CITY OF ALBUQUERQUE

March 02, 2017

Re: Peter Piper Pizza
1000 Juan Tabo Blvd NE
Traffic Circulation Layout
Architect's Stamp 02-20-17 (J22-D012D)

PROJECT TITLE: PETER PIPER PIZZA
1000 JUAN TABO BOULEVARD
ALBUQUERQUE, NEW MEXICO
JOB NO.:
DRAWN BY: J.S. SAF
PROJECT MANAGER: JON STERN
SHEET TITLE: TCL SITE PLAN
DATE: 2/1/16
SCALE: 1"=20'
SHEET: 1 of 1

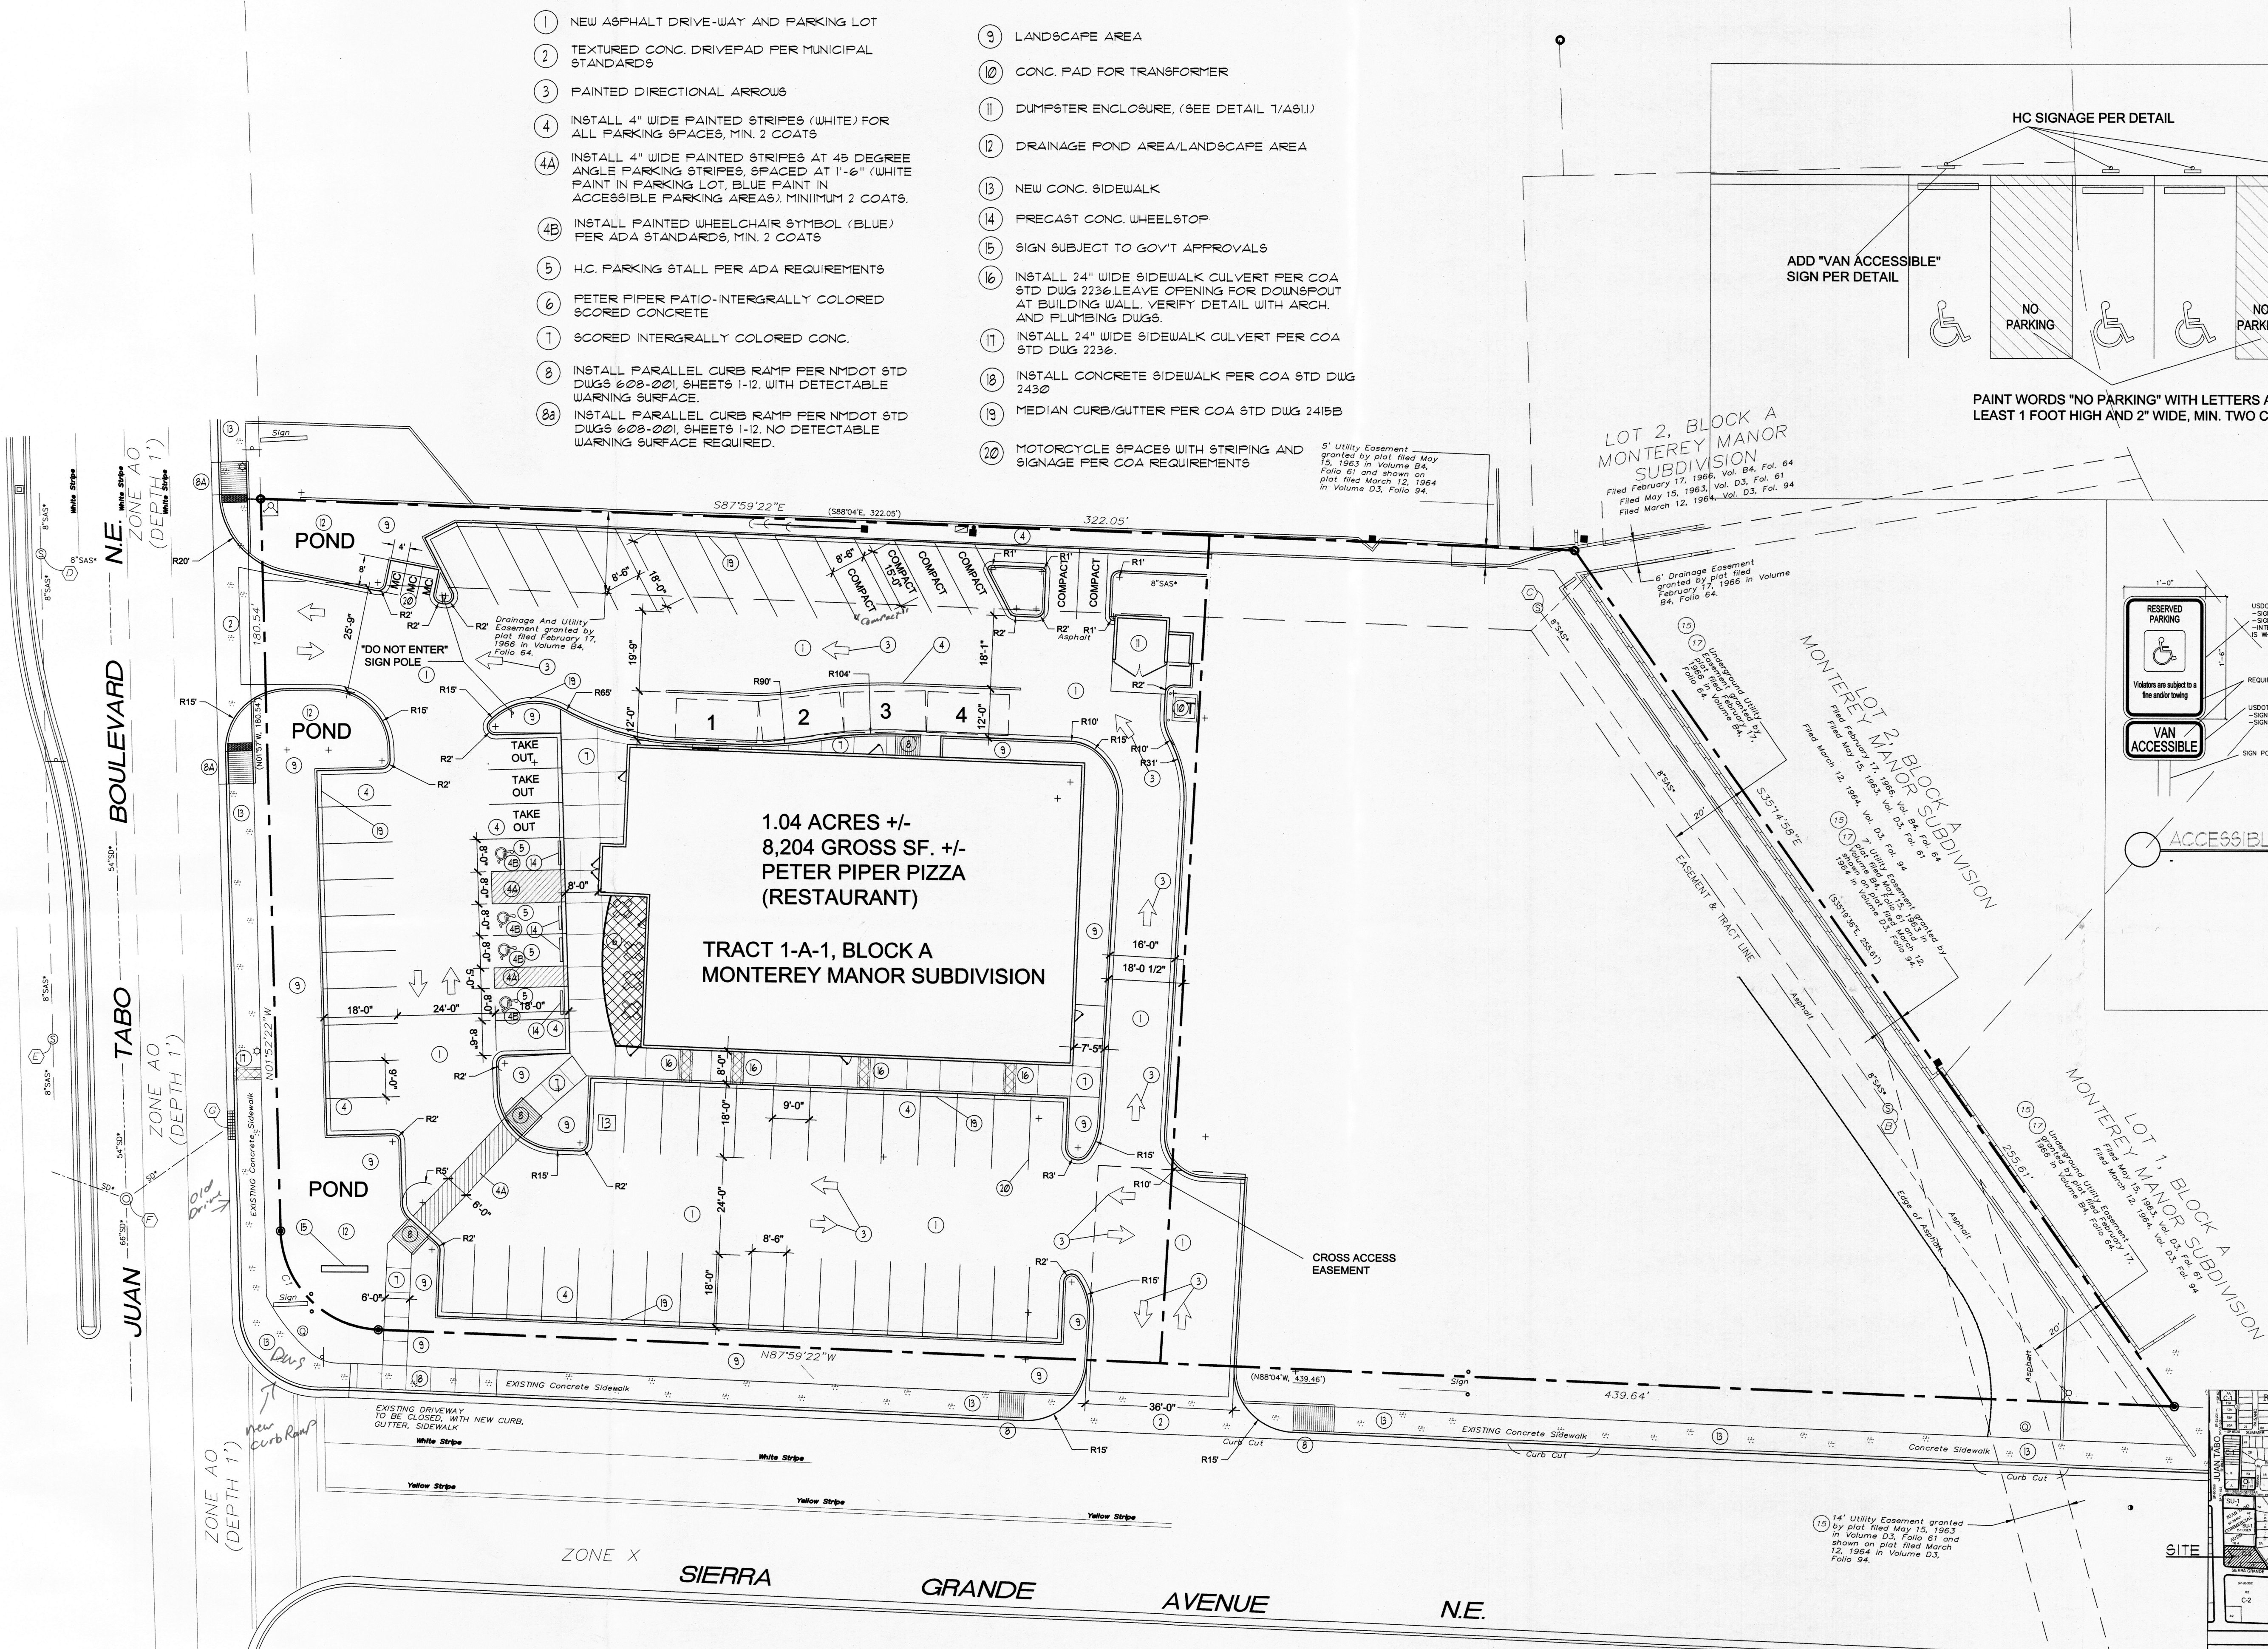
1. Label the compact parking spaces by placing the words "**COMPACT**" on the pavement of each space. Please dimension the spaces.
2. ADA accessible pedestrian pathway should not be placed behind parking space or adjacent to a vehicular way. Vehicle and pedestrian/wheel chair conflicts should be avoided as much as possible. Please clearly show this pathway and provide details. Is a ramp needed to access the building from the ADA parking spots?

3. Please specify the City Standard Drawing Number when applicable. Note 13 shows new sidewalk and should use the standard.
4. The ADA curb ramp at the intersection of Juan Tabo and Sierra Grande will need truncated domes installed and should maintain ADA accessibility.

5. Unused curb cuts must be replaced with sidewalk and curb & gutter. A build note must be provided referring to the appropriate City Standard drawing. There is one Curb cut on Juan Tabo that is being closed but is not identified.
